COMMUNITY SERVICES DEPARTMENT

Subject: Christian Brothers Automotive Review #2 (PPR183)

The Planning Division of the Community Services Department has reviewed the Christian Brothers Automotive Site Development Plan / Special Use Application Review #2 and has the following comments on behalf of El Paso County Parks.

CHRISTIAN BROTHERS AUTOMOTIVE - FALCON
PRELIMINARY GRADING PLAN

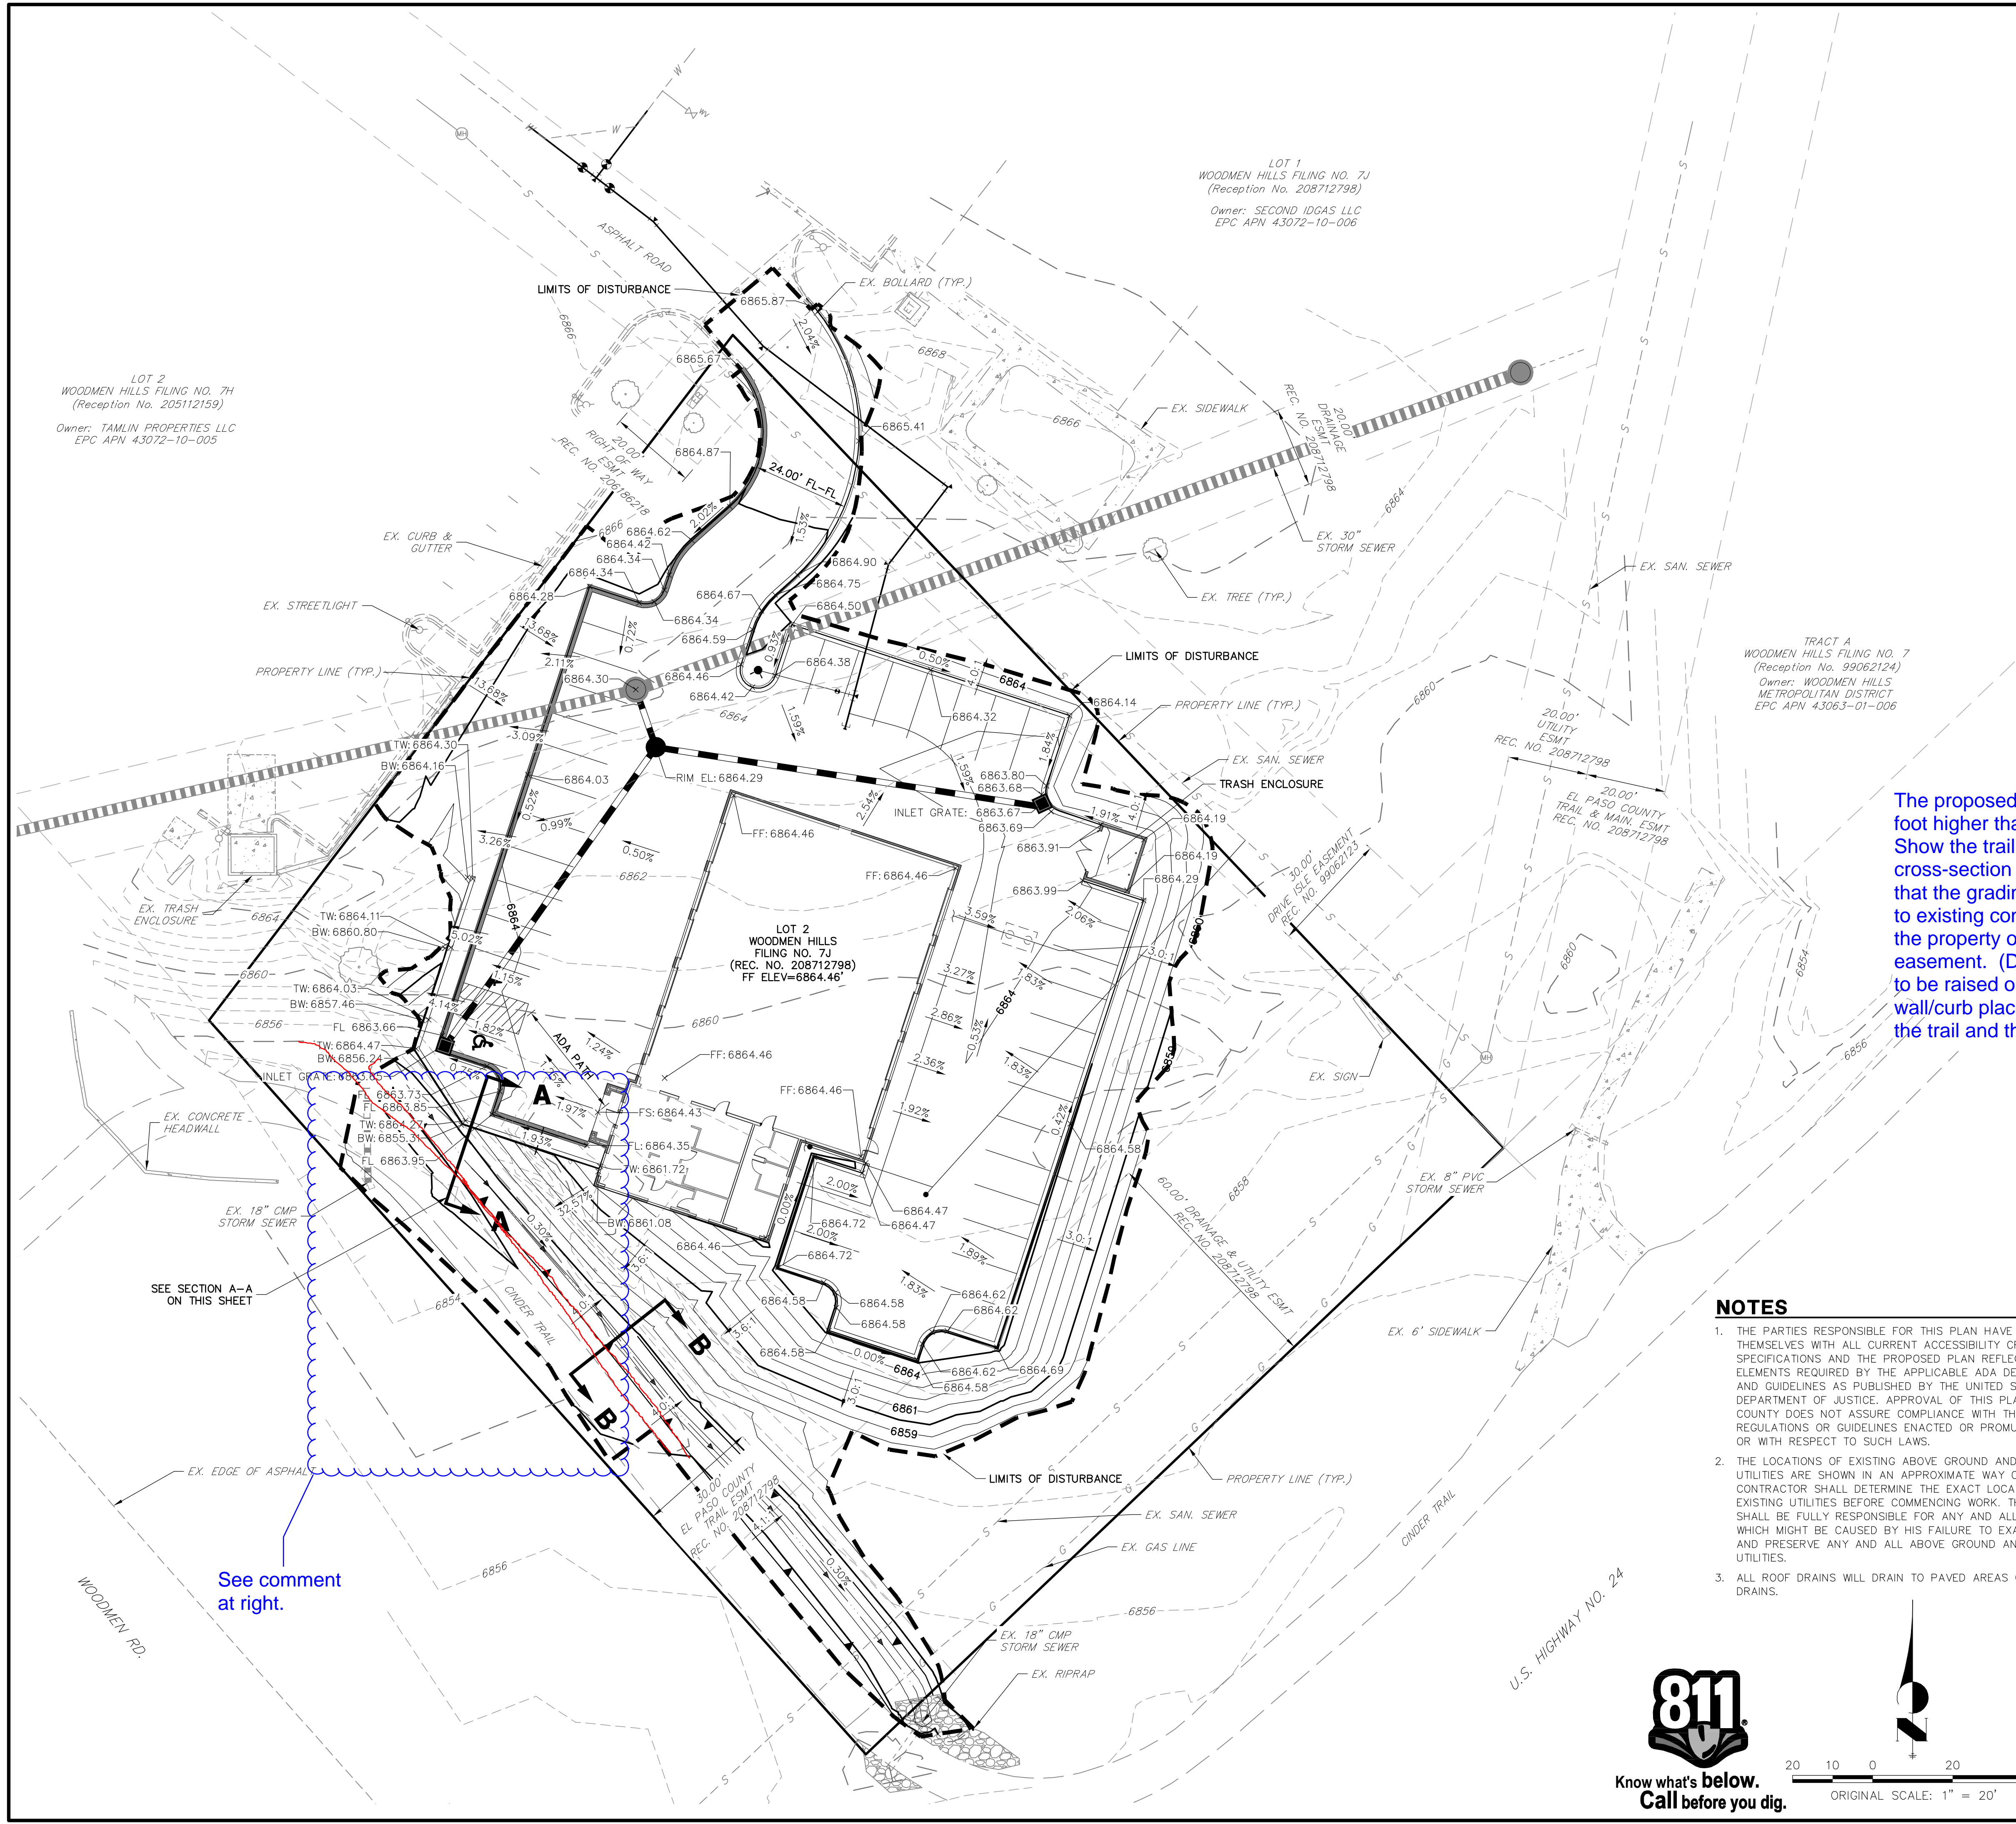
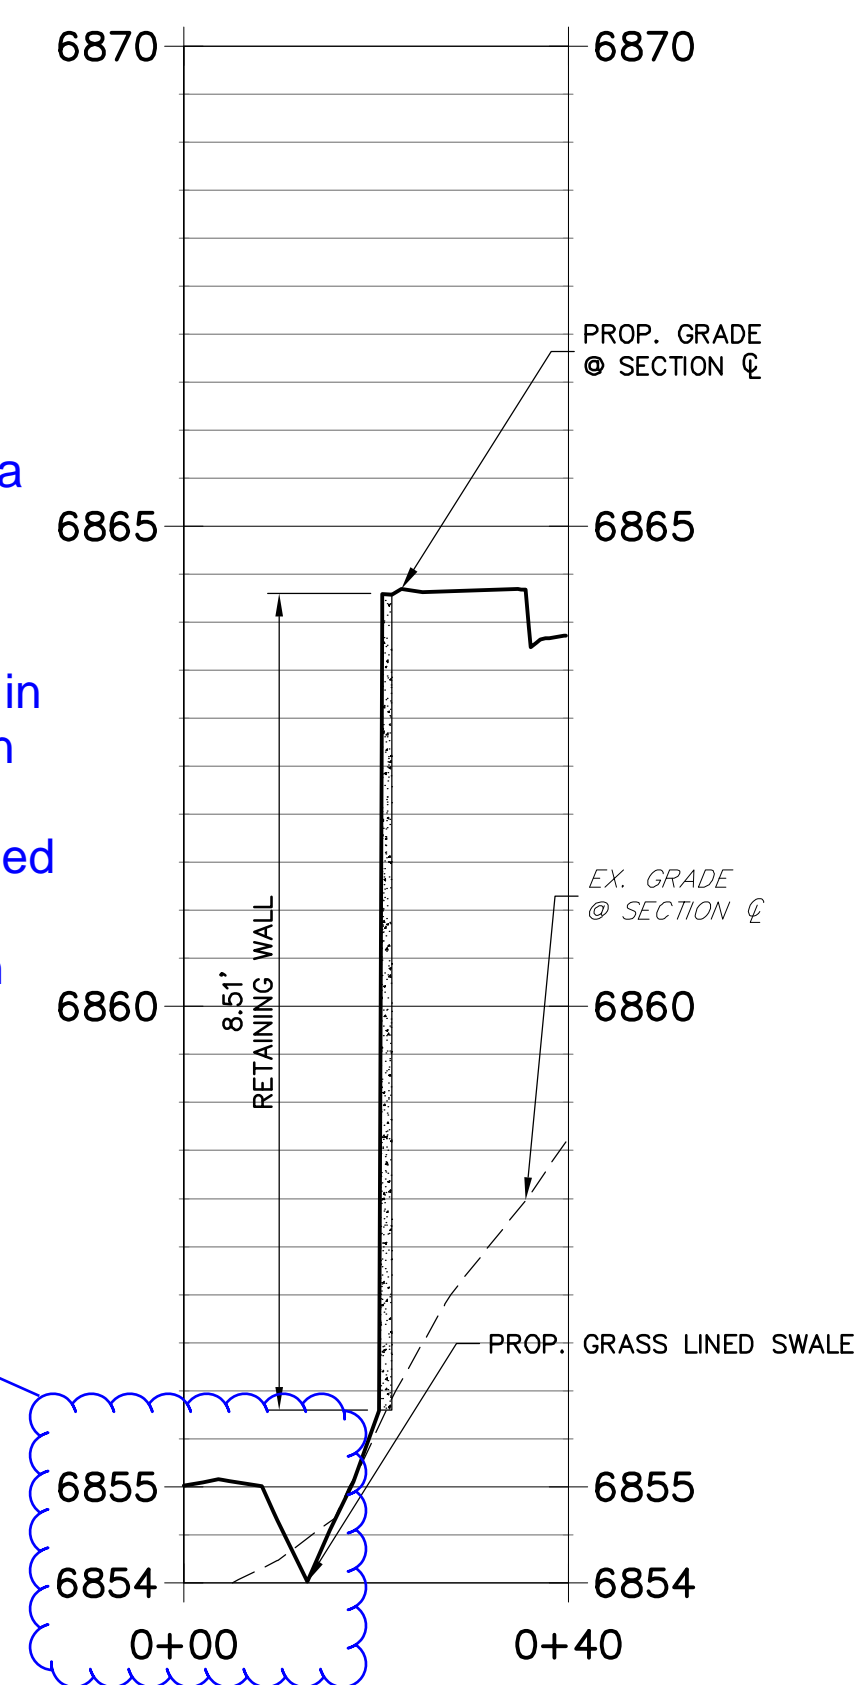
The preliminary grading plan was revised to include a grass-lined ditch running adjacent to the trail, within the trail easement, as requested by Parks staff to drain runoff away from the trail.
